REQUEST

Current Zoning: B-1 (neighborhood business) and R-5 (single family residential)
Proposed Zoning: NS (neighborhood services)

Approximately 0.76 acres located on the western side of Tuckaseegee Road between Camp Green Street and Berryhill Road.

The petition proposes to redevelop the site to allow all uses in the NS district in up to 16,000 square feet of building area.

REZONING PETITION
#2020-157

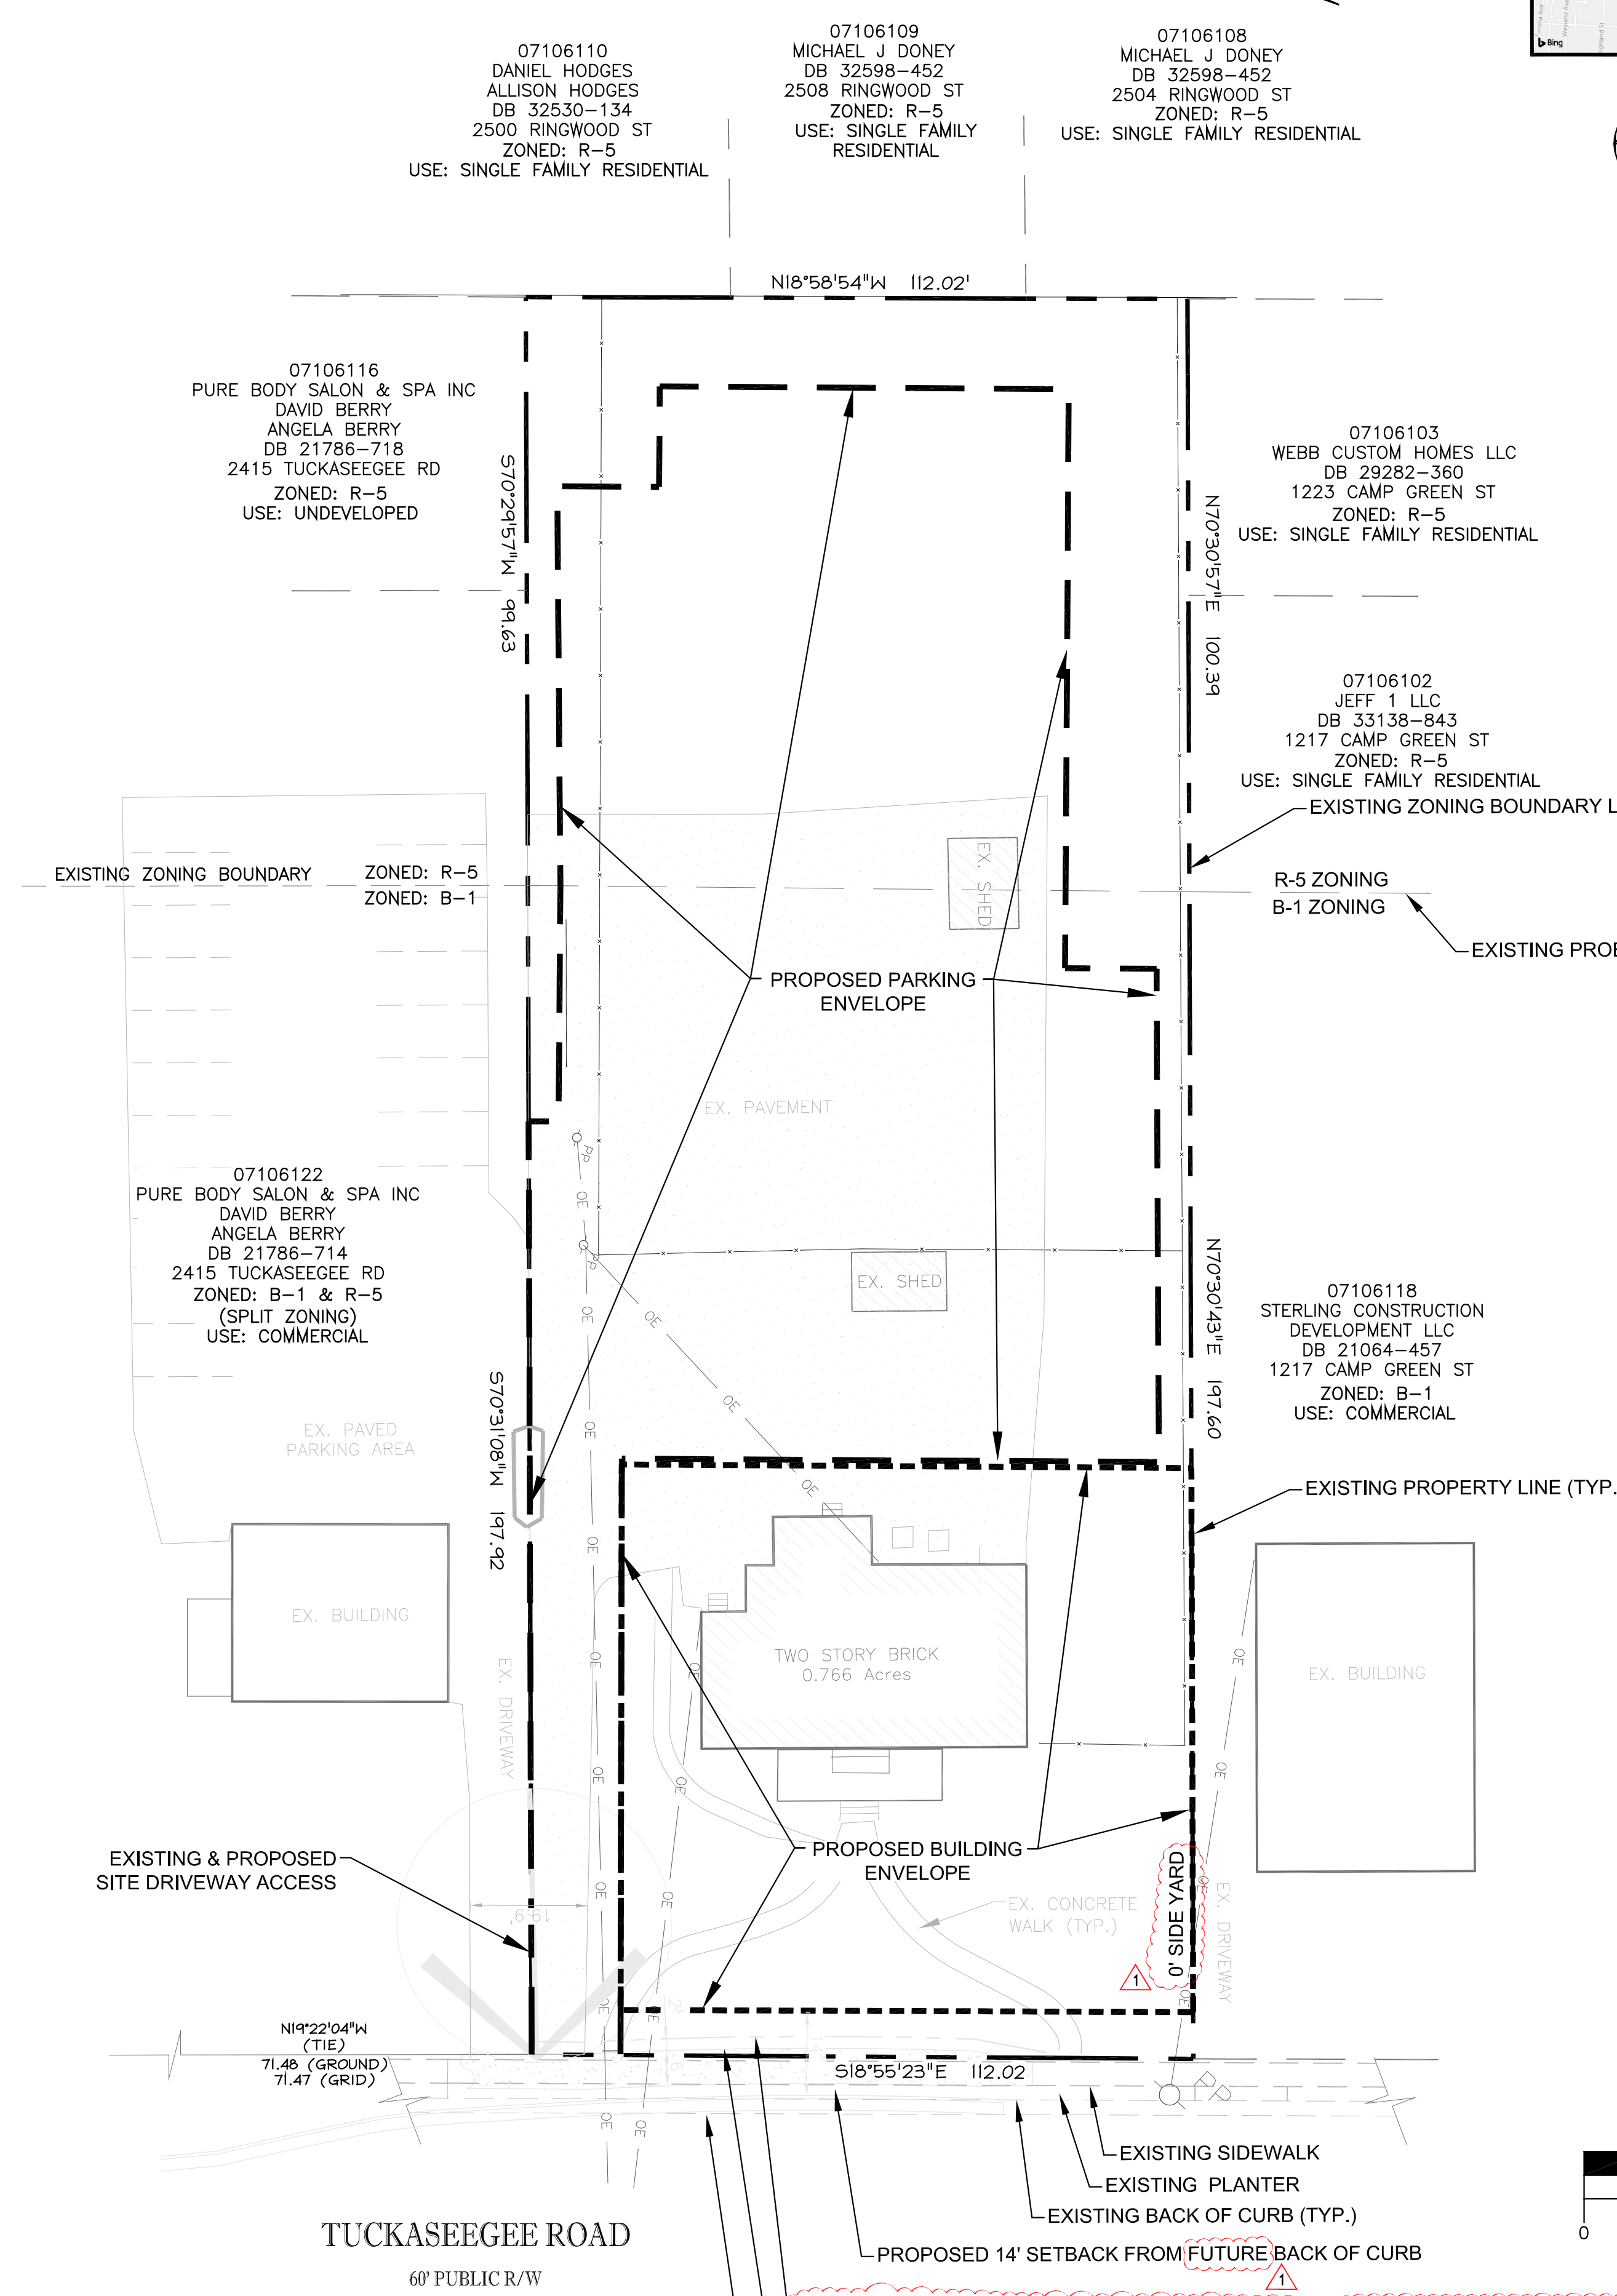
2. Revisions are needed on the site plan and conditional note (Section 7.B) to relocate the proposed 8-foot planting strip to the Tuckaseegee Road back of curb, separating the proposed 6-foot sidewalk from the roadway, as required within Chapter 19-174 of the City Code, to allow the planting strip to function as necessary. **OUTSTANDING**

6. ~~Revise note 7.B to state a setback of 22' to match the setback shown on the site plan.~~
OUTSTANDING
